DECISION DELEGATED TO HEAD OF PLANNING

Application No: H02-0593-26 **Applicant:** Mr M Woodroffe
Proposal: Erection of Single-Storey Extension and Car Port
Location: 15 Barbers Drove South Crowland
Terminal Date: 25th August 2026

Drawing Title:
Proposed Plan and Elevations

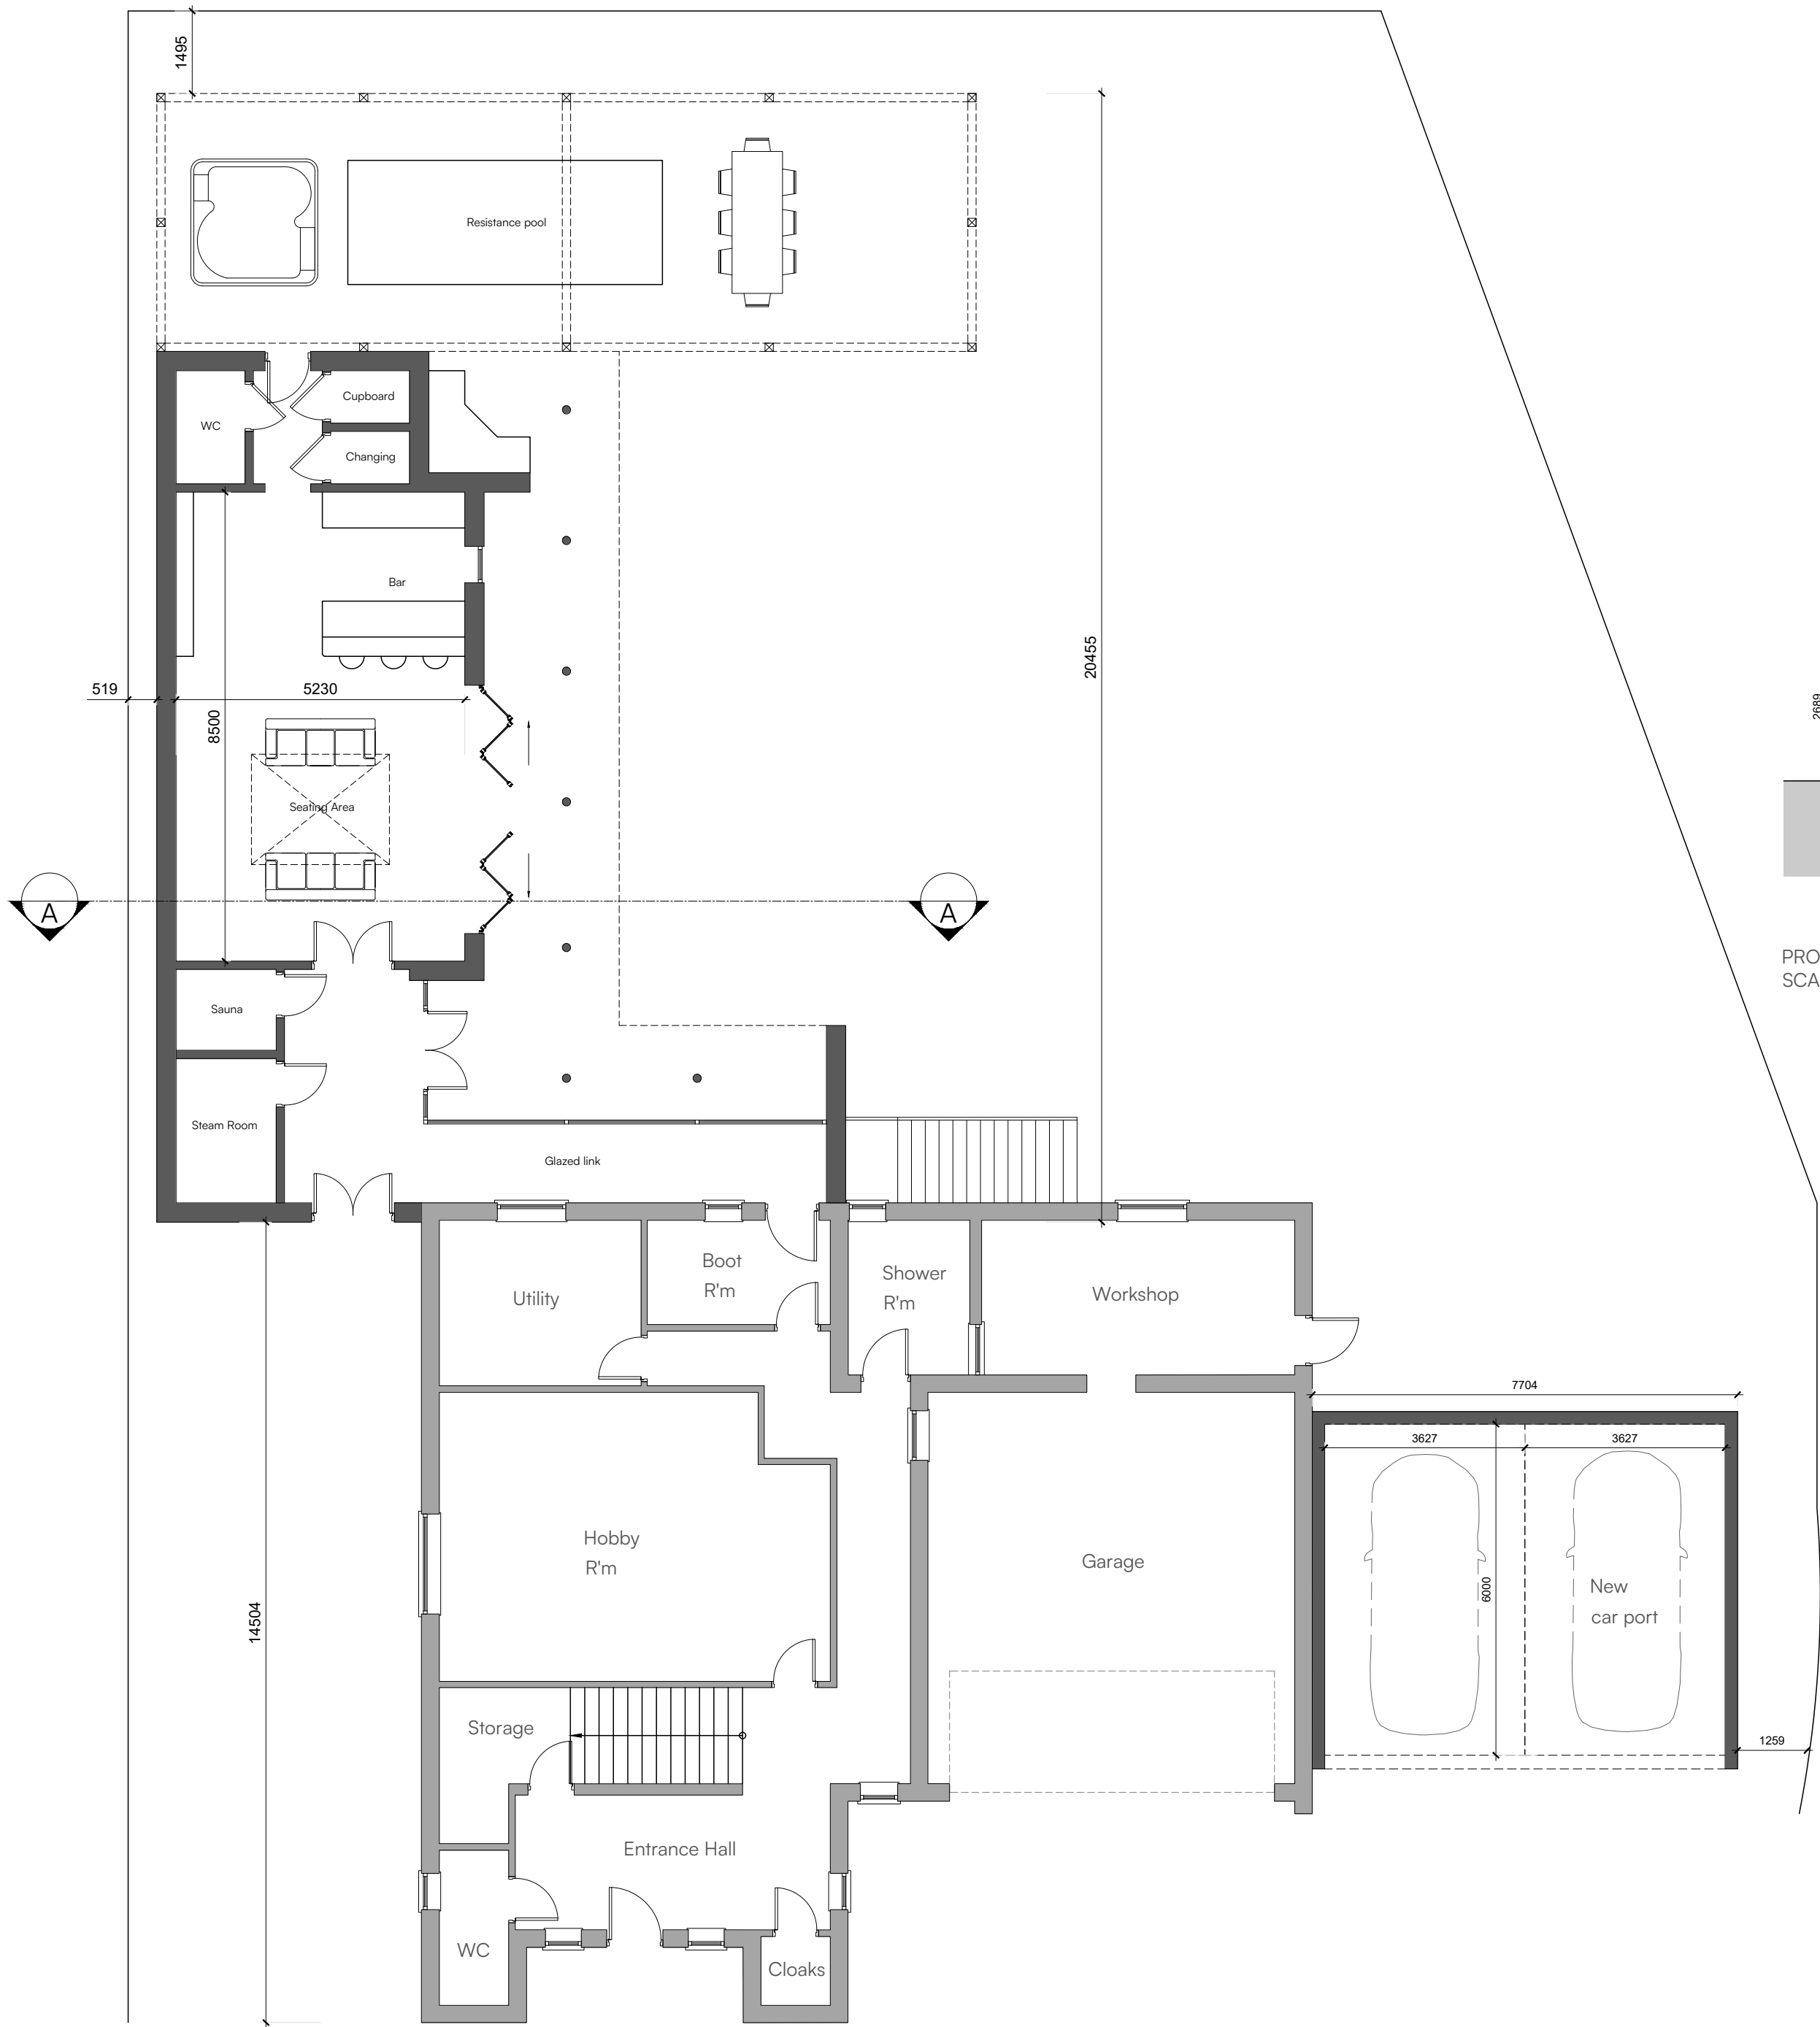
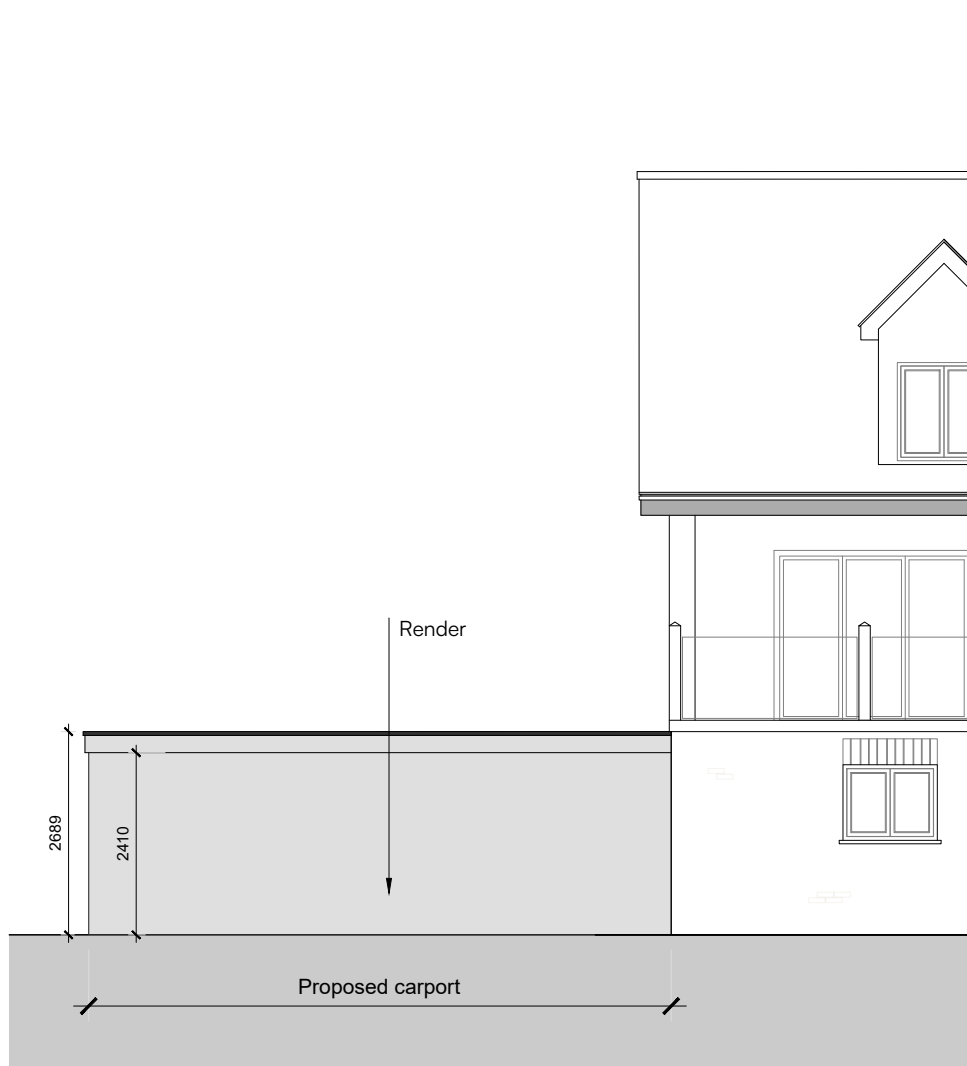
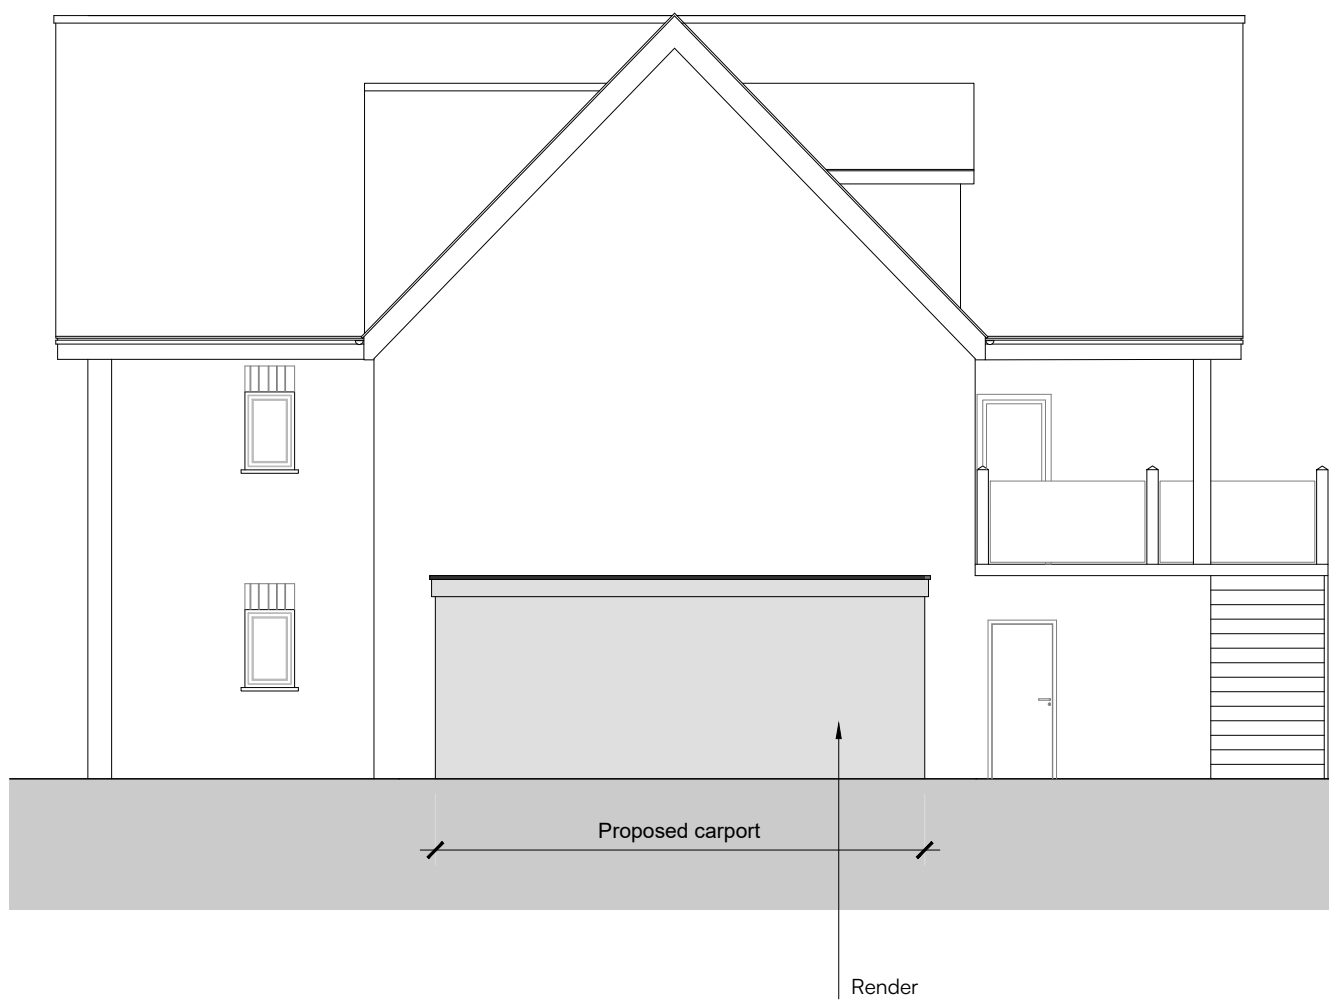
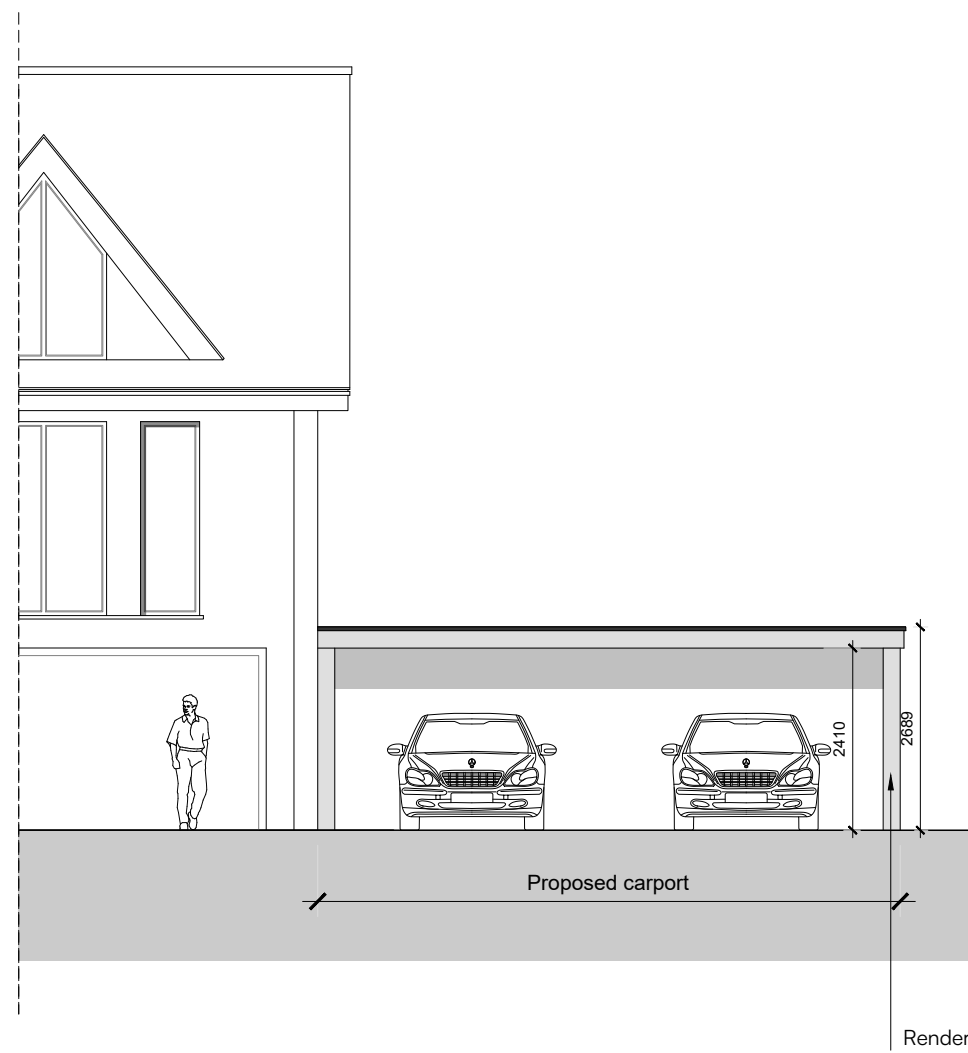
The car port is proposed on the south-eastern side of the dwelling. Initially, the car port was proposed to feature a flat roof form; however, this was amended to a gable end roof form during the determination of the application.

The dwelling currently features gable end roof forms and as set out previously, the roof form of the proposed car port was amended during the determination of the application to a gable end roof form to correspond with the host dwelling. Initially, a flat roof form was proposed for the carport and it was considered that this would have jarred with the host dwelling. The revised roof form is considered to be acceptable on balance. Although the ridgeline is relatively tall for a side extension, the overall dwelling is relatively tall and the roof pitch of the car port matches the roof pitch of the existing dwelling.

No windows are proposed on the north-western elevation of the extension which is near to the boundary with 11 Barber's Drove. As such, the extension is not expected to result in an increase of overlooking with No. 11.

The extension would be located close to the site boundary with No.11; however, due to the height of the extension (2.8m), it is considered that the proposal would not result in an unacceptable loss of light to the rear garden of No. 11.
